### ES FIGURE 14.4 - MAIN HNRFI SITE CONCEPT SURFACE WATER DRAINAGE STRATEGY

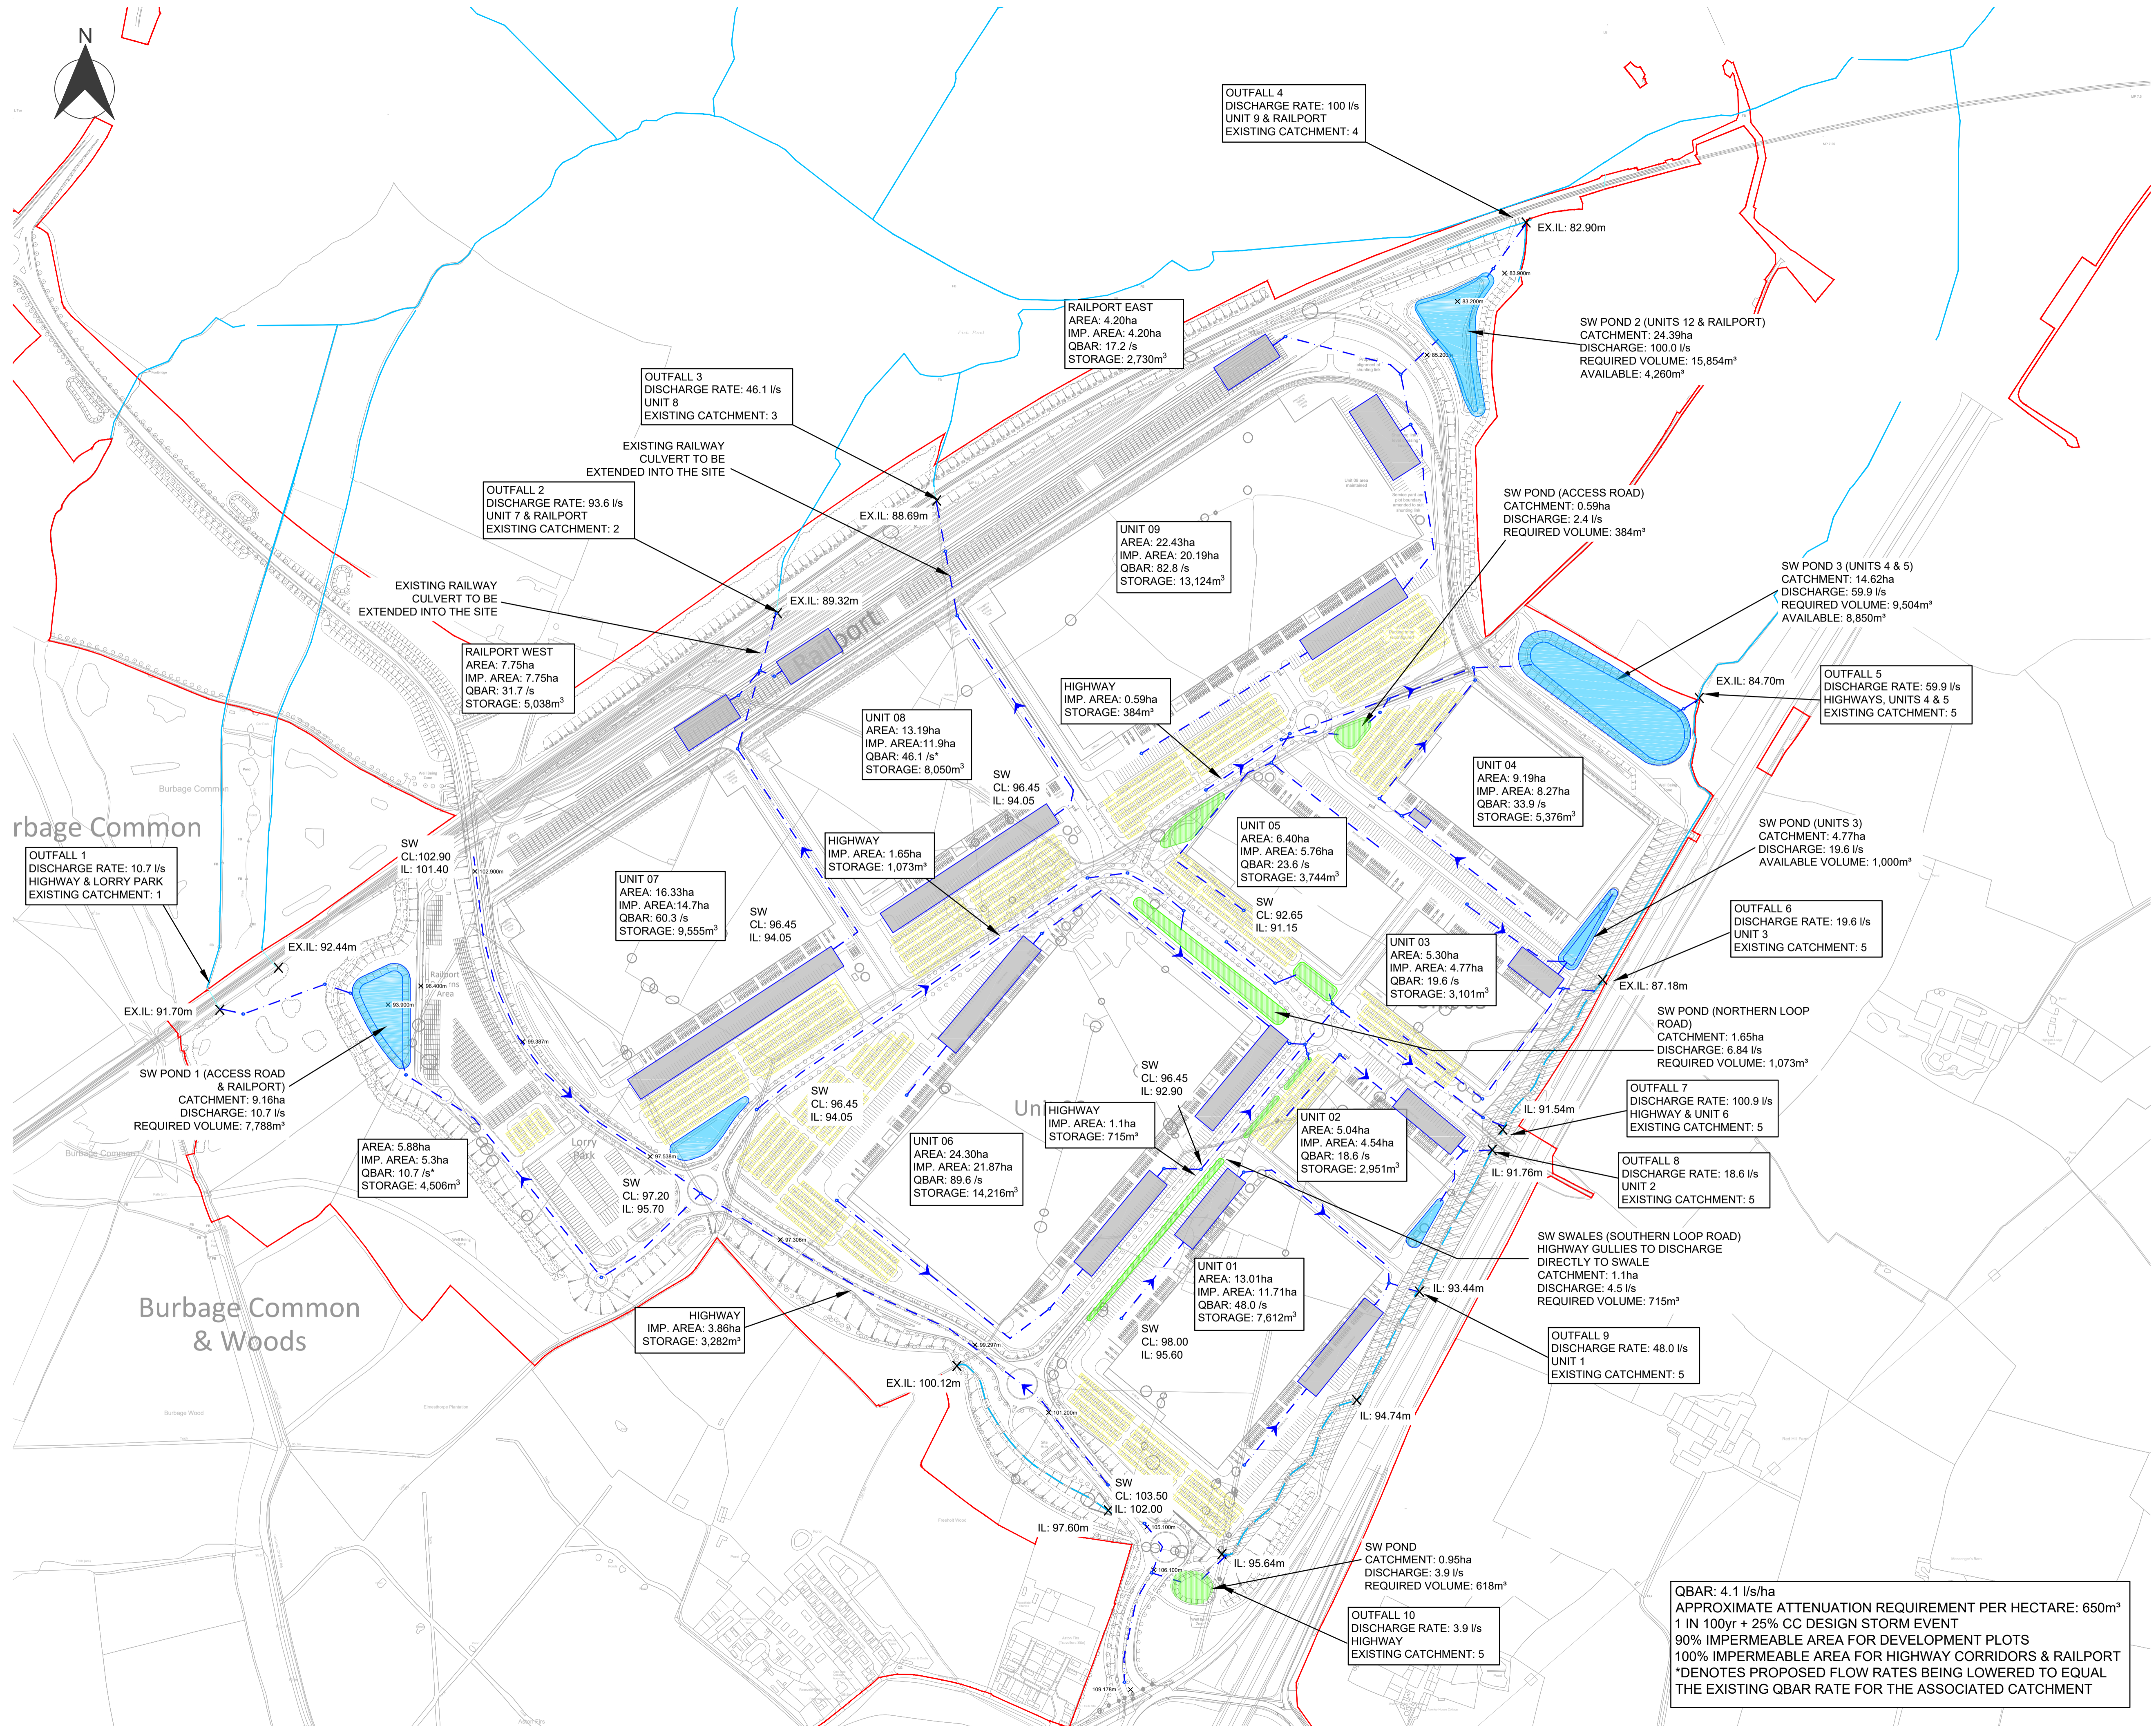
Requires extensive changes in ground levels which affects surface and ground water flows. Applicant's latest revised submissions now agree this is permeable ground, which highlights the previously dismissed questions on the altered above and below ground water supplies to the SSSI and Burbage Common.

Cut and Fill balance depends on having suitable material. Otherwise substantial CO2 requirement to extract and replace. Any confirmation for this ?

Existing Utilities, Features & Areas of Influence - Key Plan

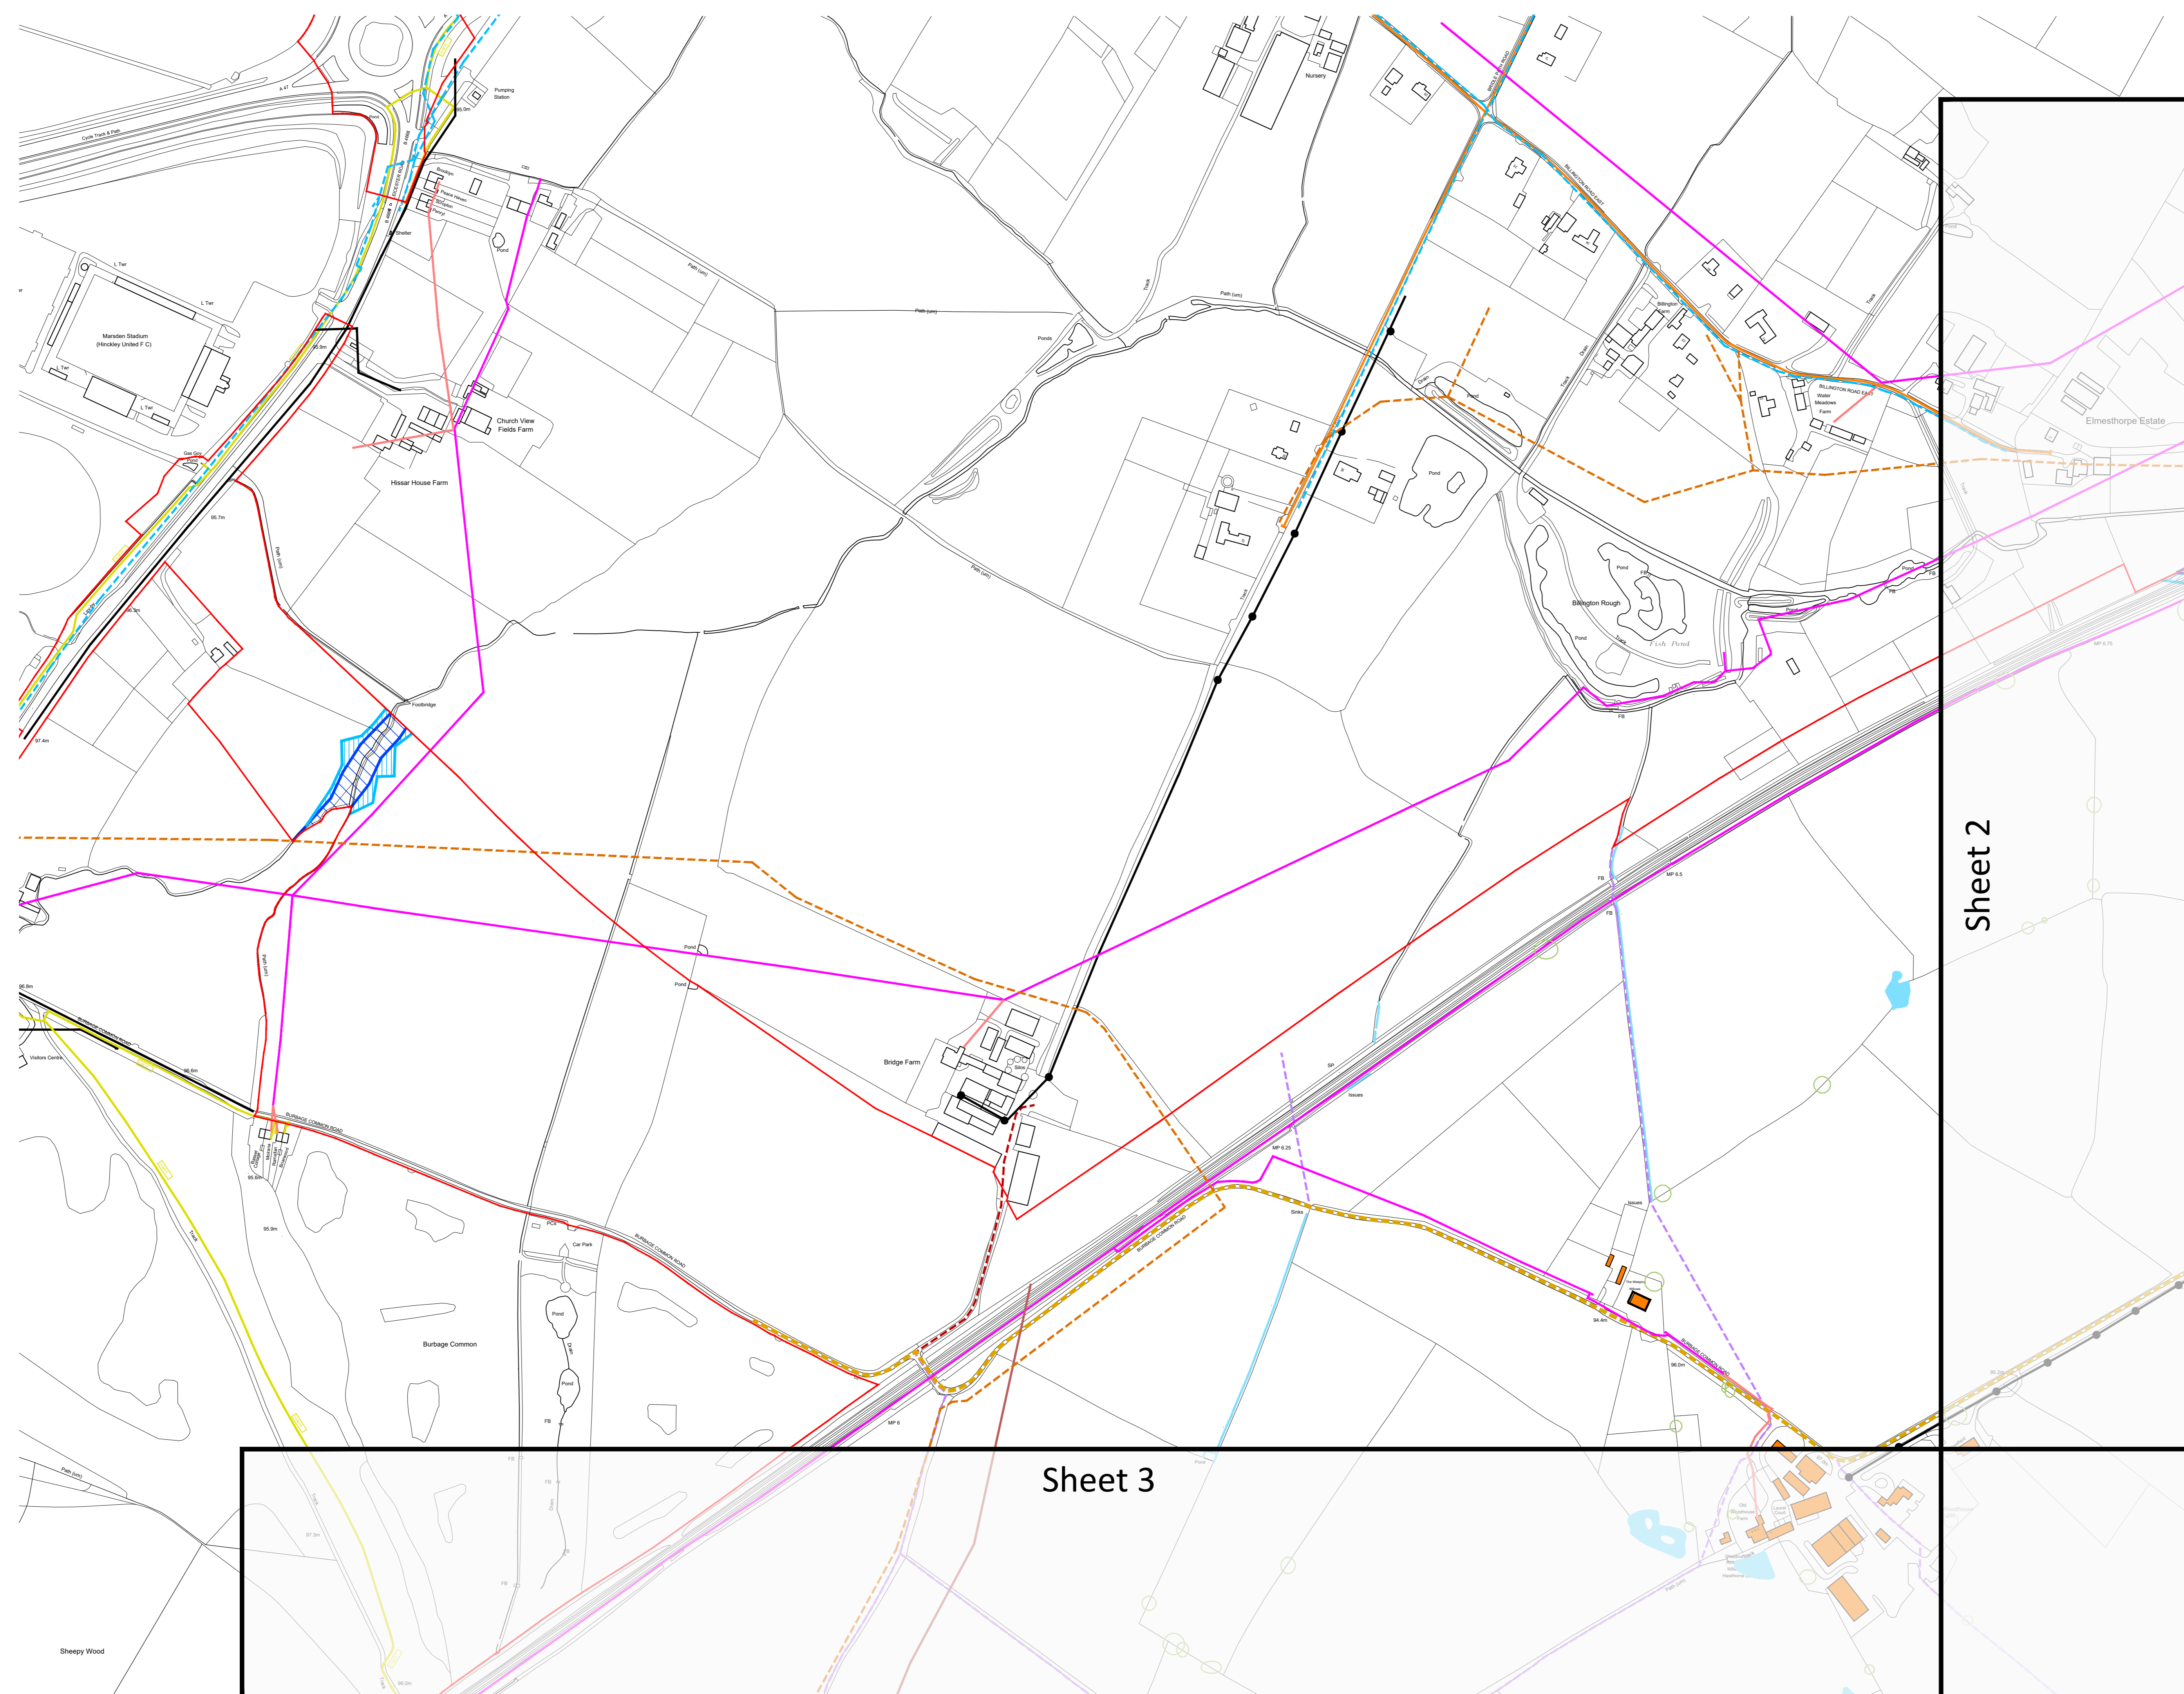
Requires diversion of 500mm ST pressurised sewer pipe – is there a diversion plan agreed with Severn Trent ? Is it planned before (during ??) the earthworks phase ?
